Our Ref: Y/46/19/DOC

Town & Country Planning Act 1990 (as amended)
Town and Country Planning (Development Management Procedure) (England) Order 2015
Approval of details reserved by condition imposed under ref Y/7/15/PL relating to Condition Nos 3 -
materials and 10 - insulation.
Gospel Hall adj Olive Court North End Road Yapton BN18 0DU

Arun District Council have decided to **REFUSE details reserved by condition for the following reasons:**

ient	Boundstone
b title	The Olive Branch Gospel Hall Yapton
awing title	Gospel Hall Ridge Detail

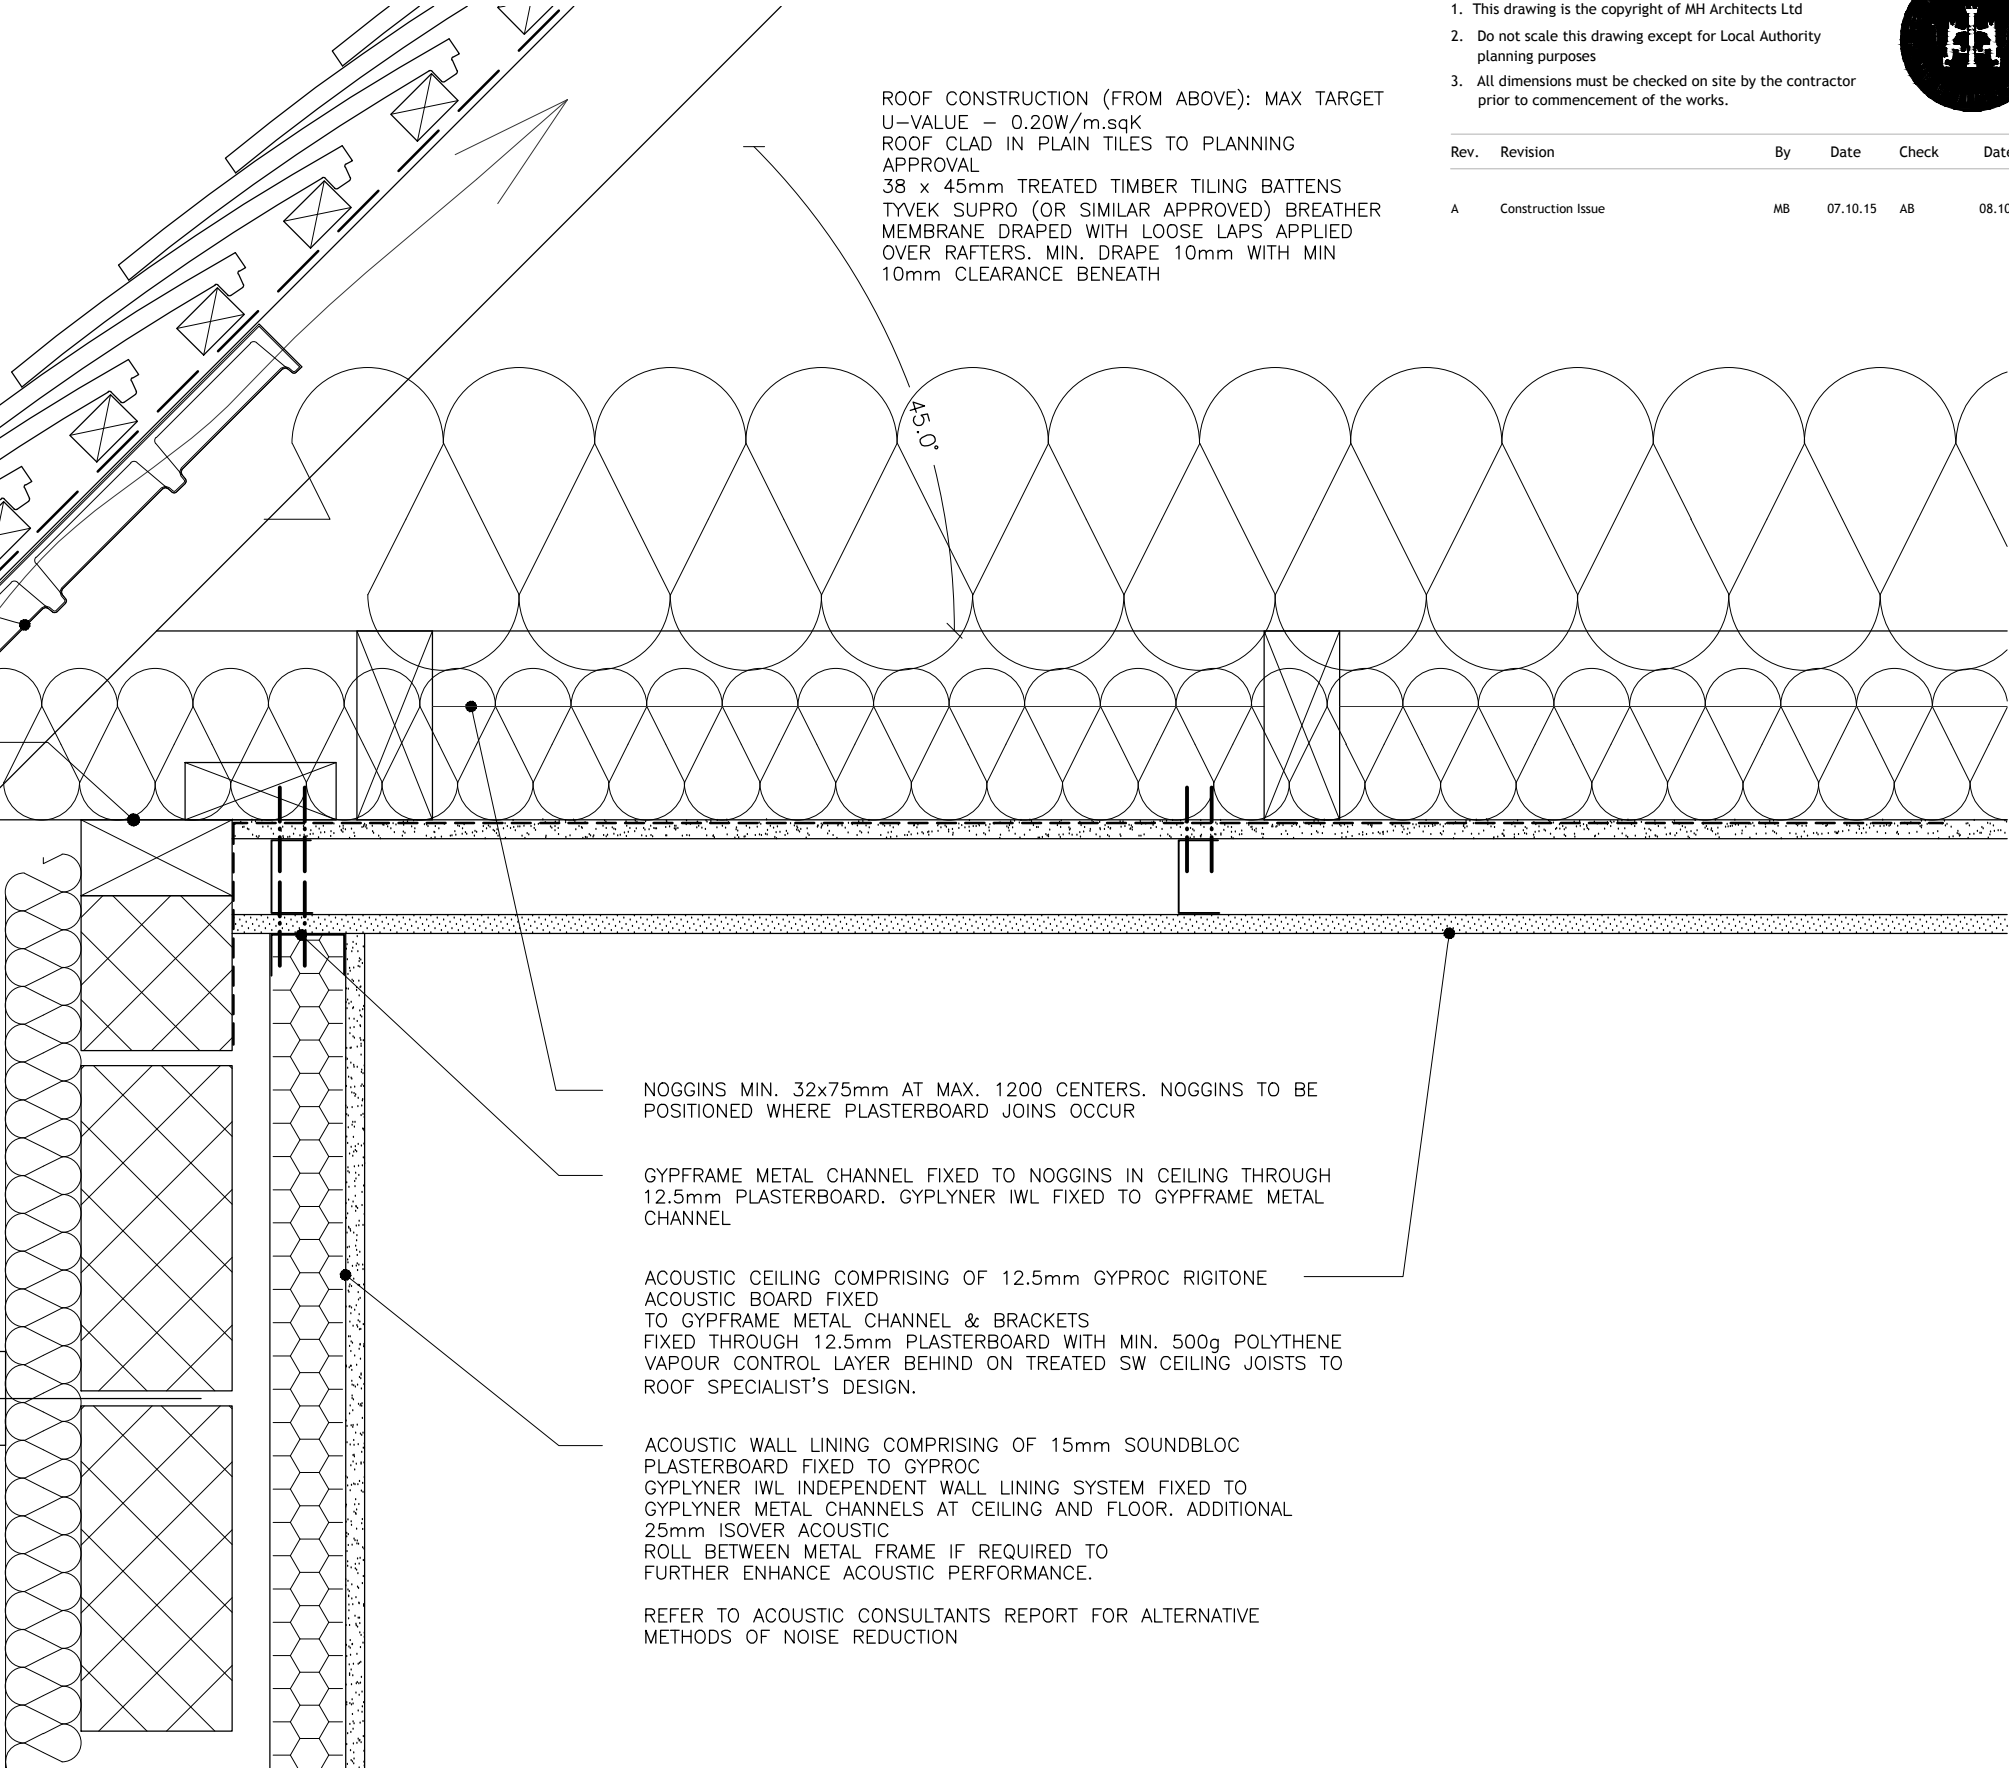
Condition 10 requires that the building be insulated in accordance with an approved noise management scheme, however the submitted document does not adequately address this condition. Based on the proposed use, the scheme should identify the potential sources of noise and illustrate the levels of noise. The scheme should then demonstrate how the noise will be managed to an acceptable level. The applicant may wish to engage the services of a suitably qualified, independent acoustic consultant to assist with this aspect.
